January 15, 2024

Re: **Kendall Auto Group Auto Storage Yard - PA 23020**
IECO No. 20-1092

The project referenced above is revised in response to the review comments dated September 26, 2023. The review comments are numbered on the letter and have been addressed in *italics* as follows:

4
C5.2
39TH AVE NE (SECTION B-B)
NOT TO SCALE DESIGN SPEED = 25 MPH
LOCAL ACCESS STREET
RIGHT-OF-WAY PER STD PLAN 3-202-003

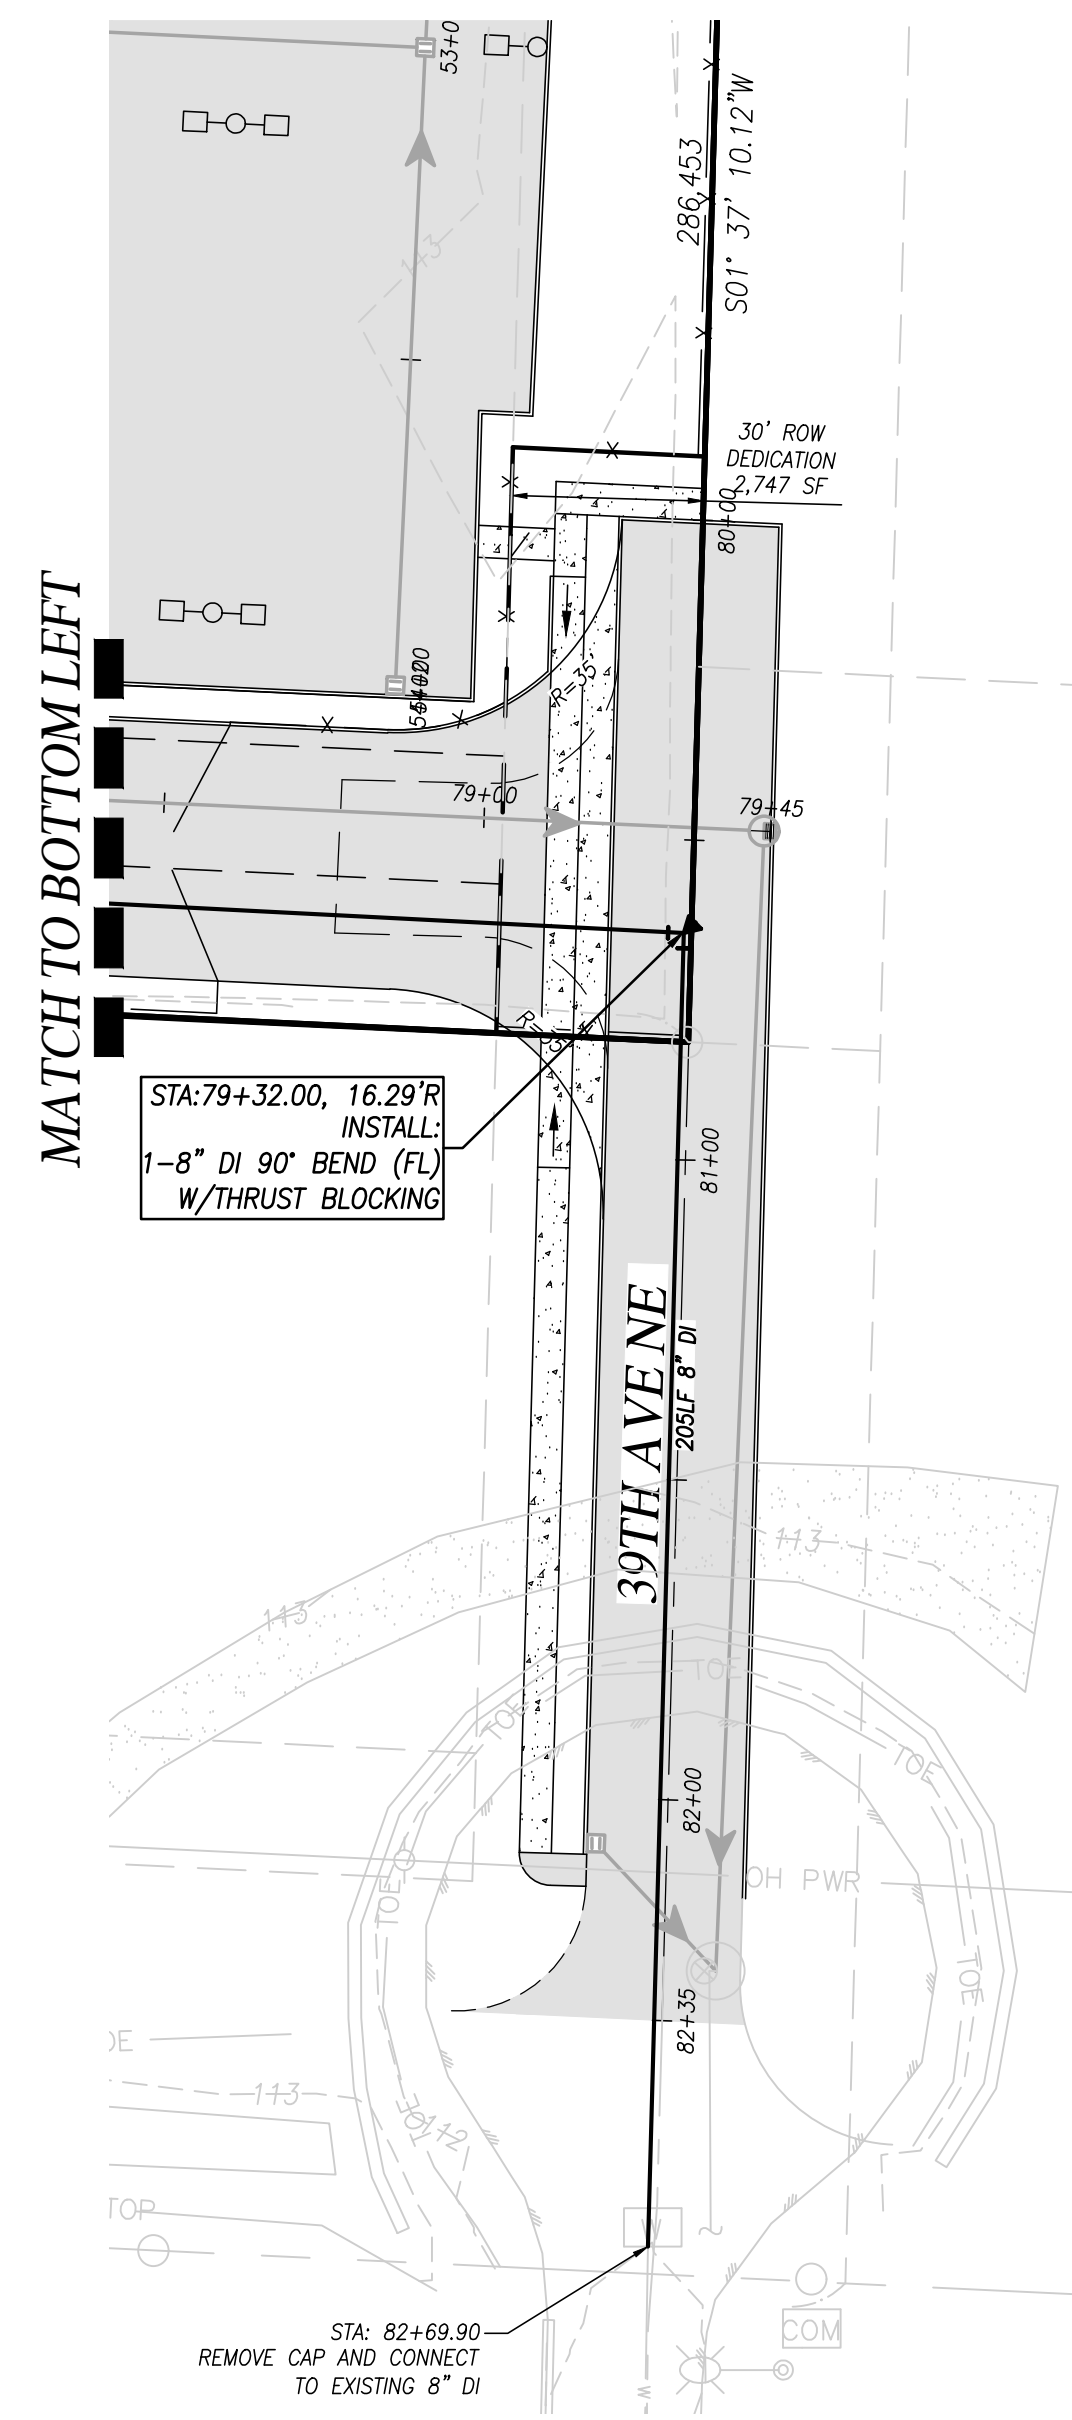
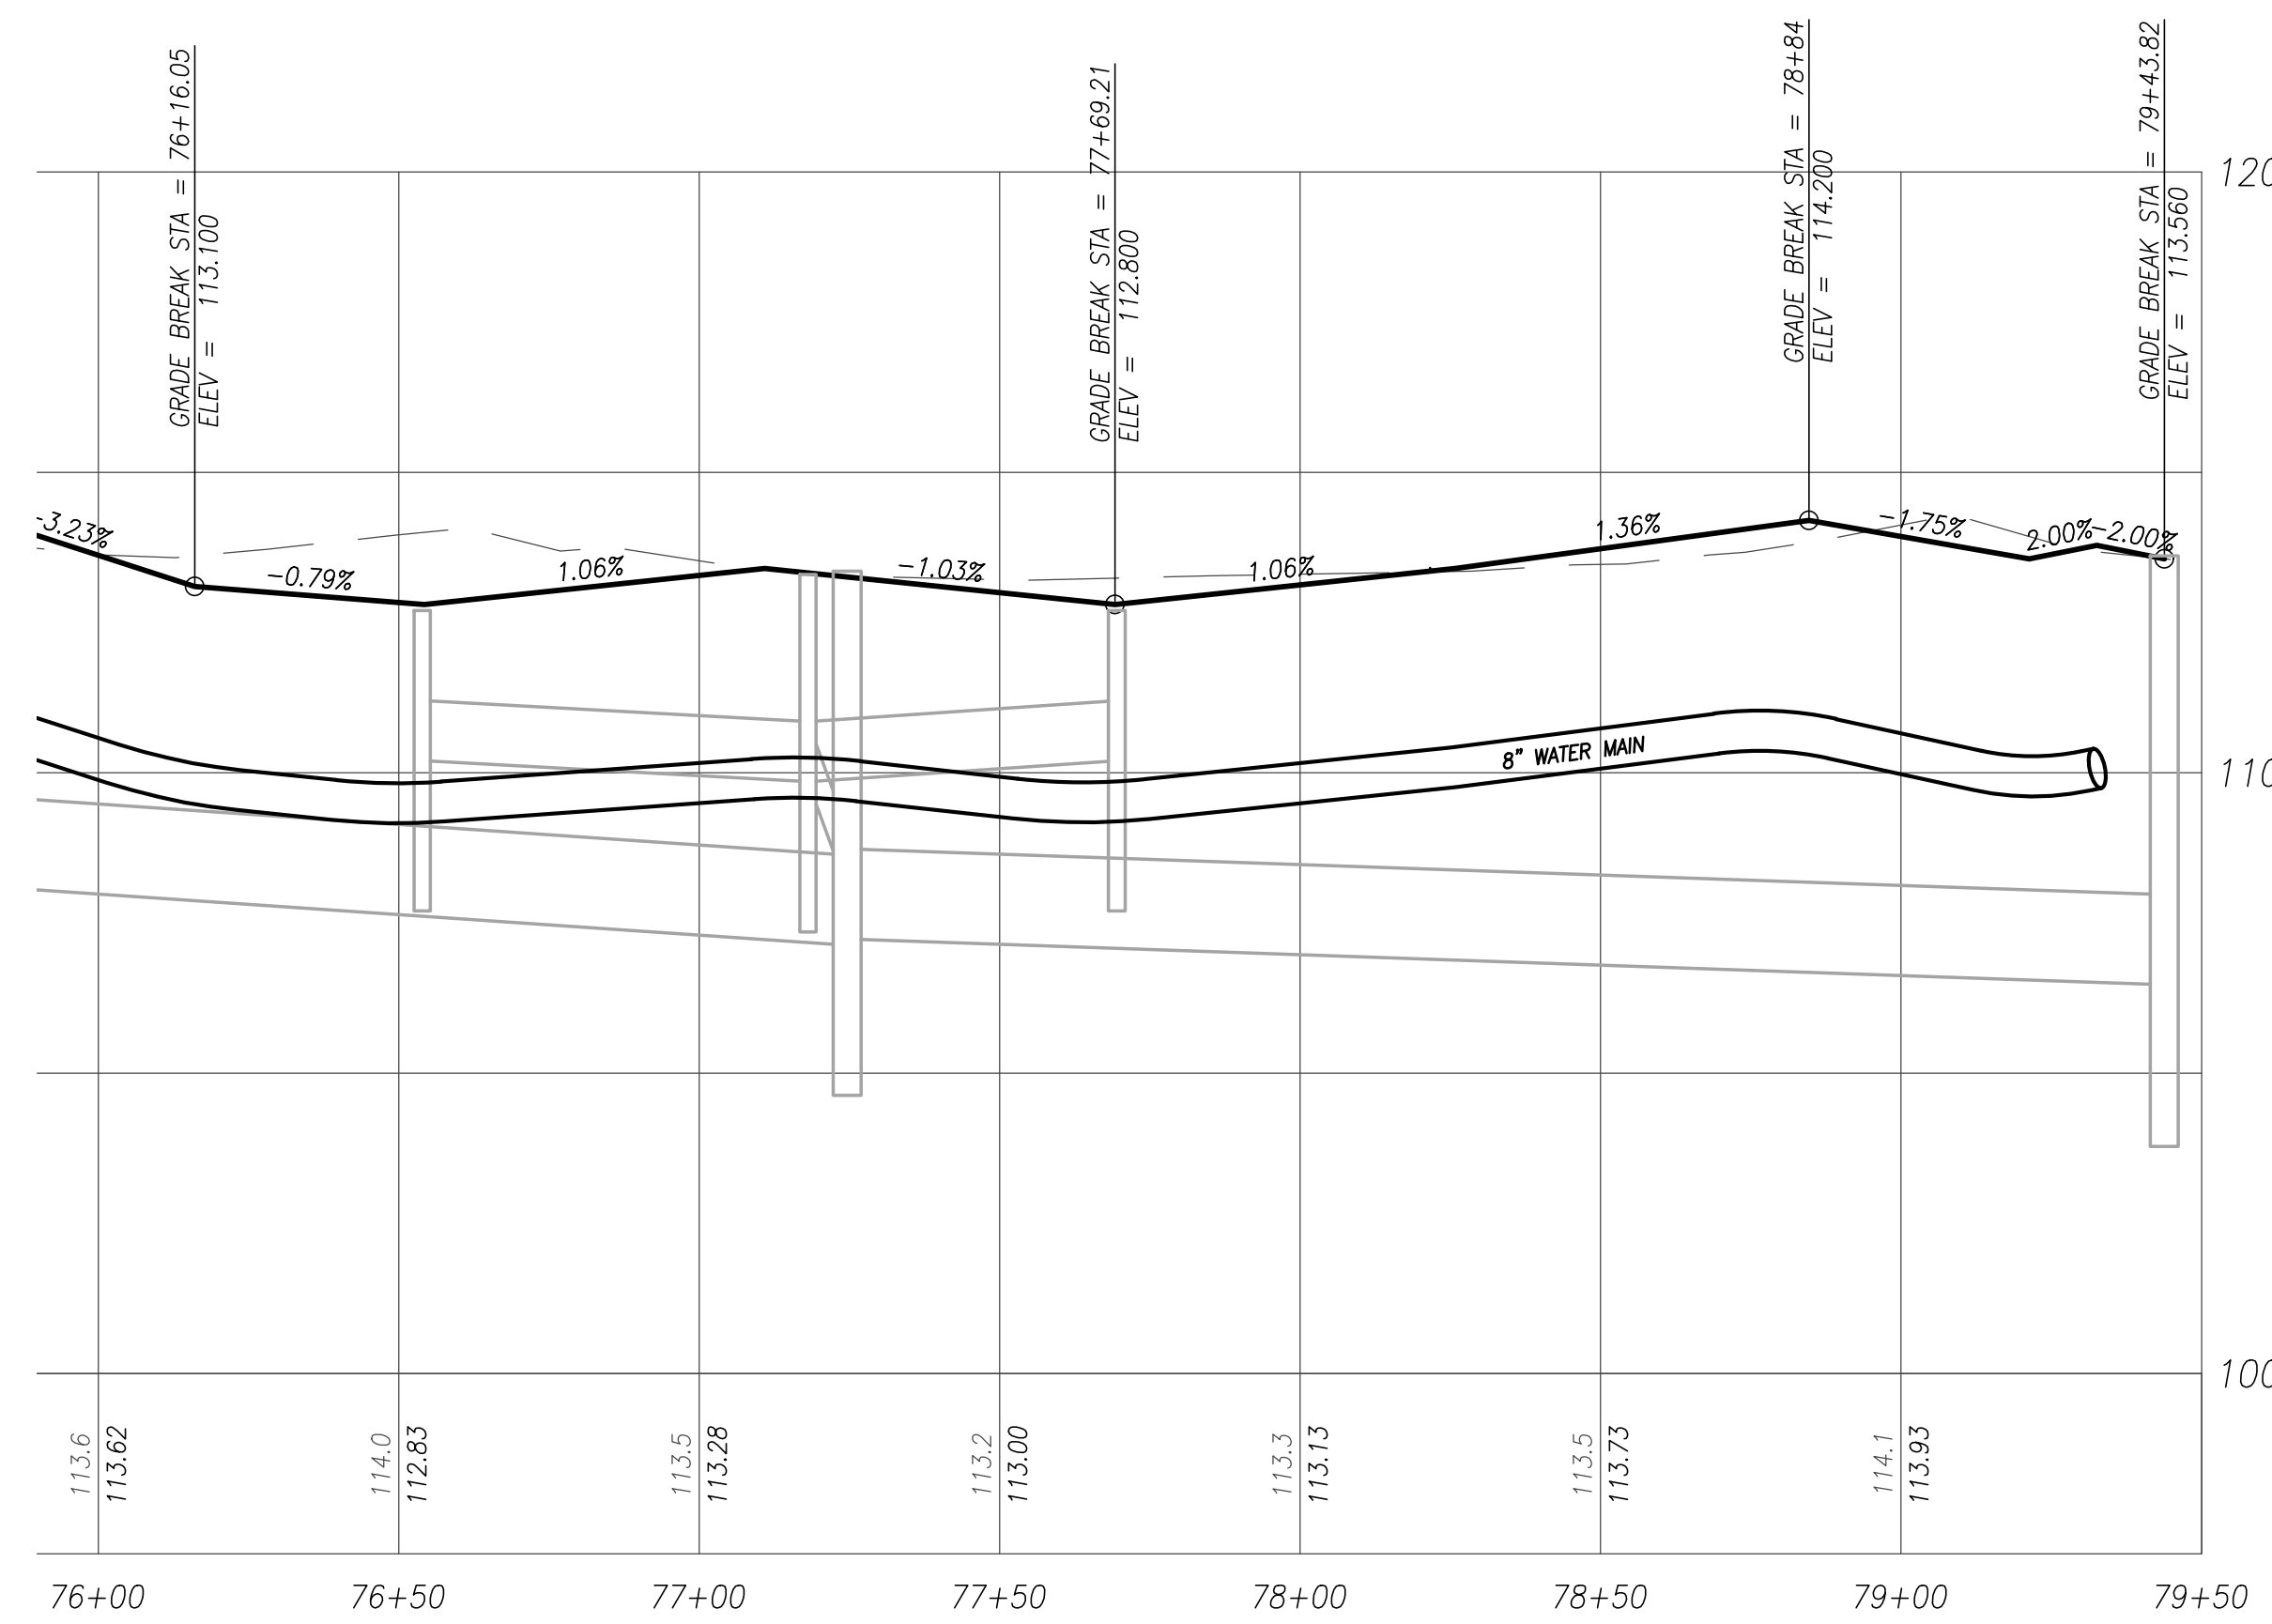
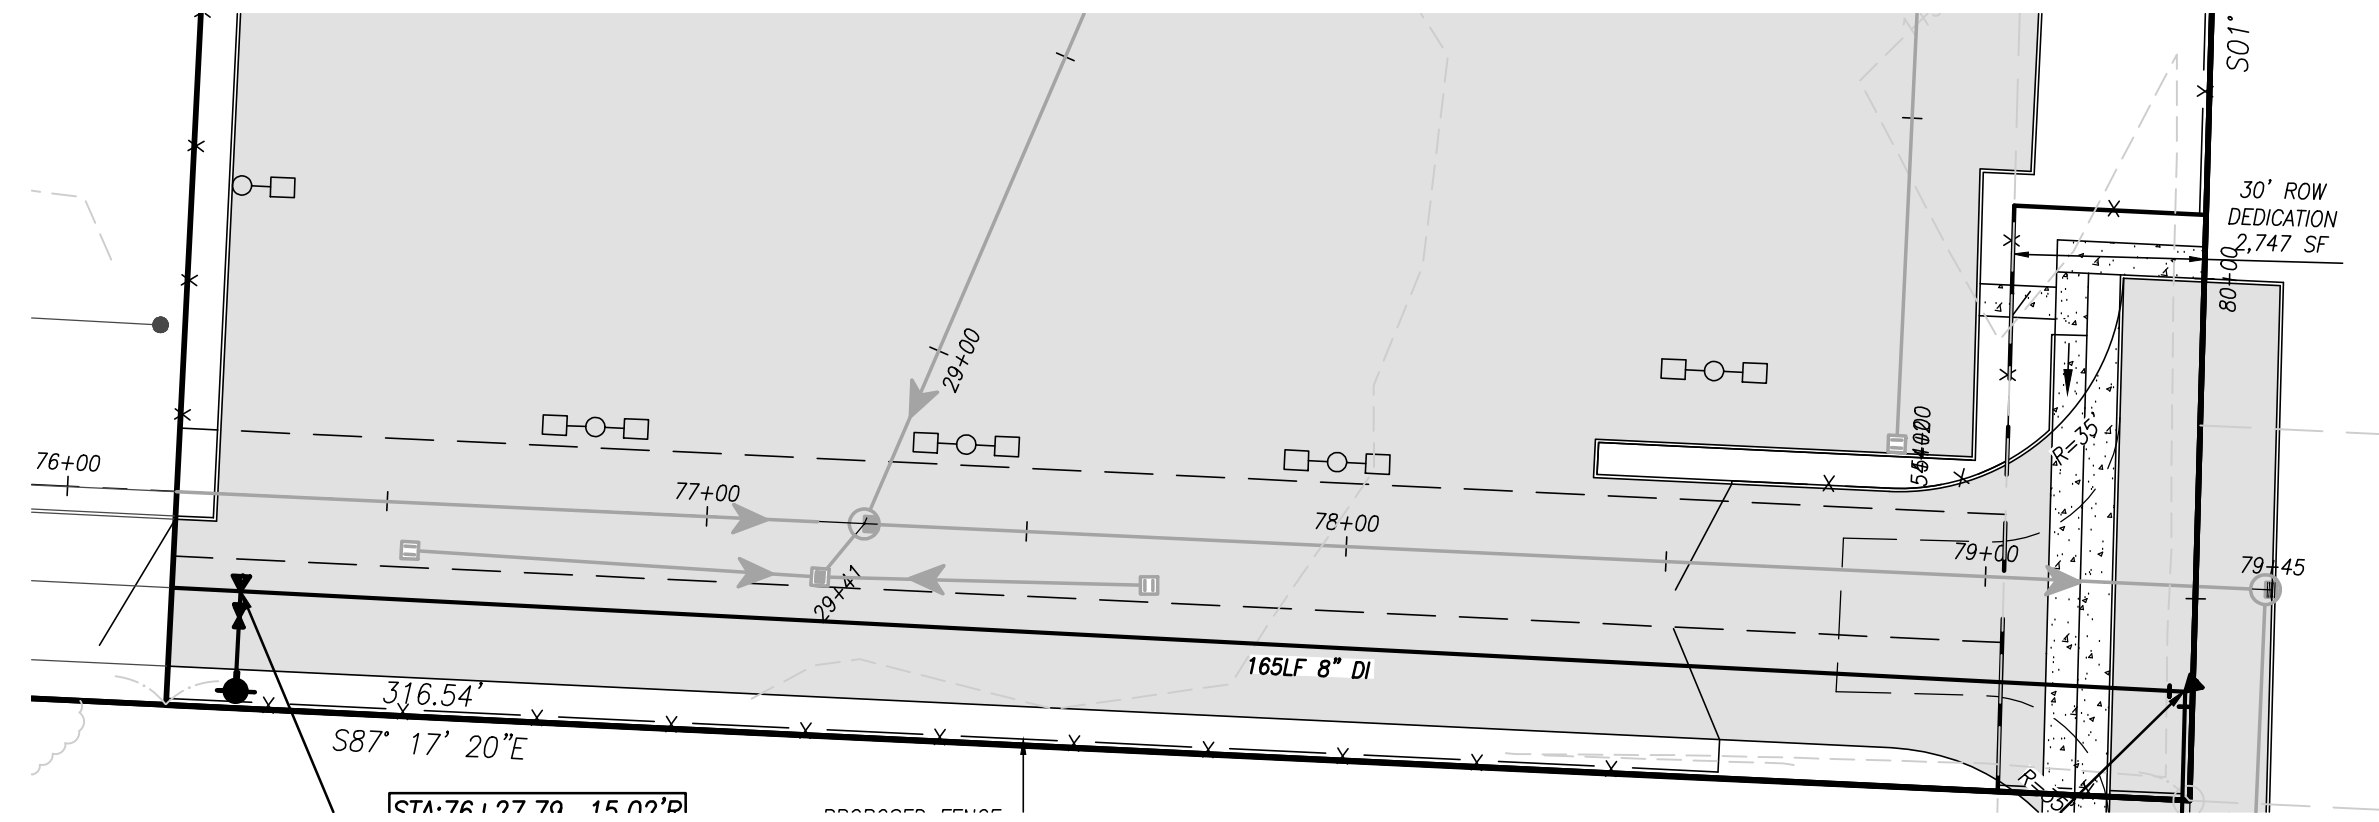
25. Frontage Improvements/Roadway construction shall be required for 39th Ave NE along eastern property line.

a. Roadway cross-section shall be per EDDS Standard Plan 3-201-003.

Please see revised 1/C5.1 and 4/C5.2.
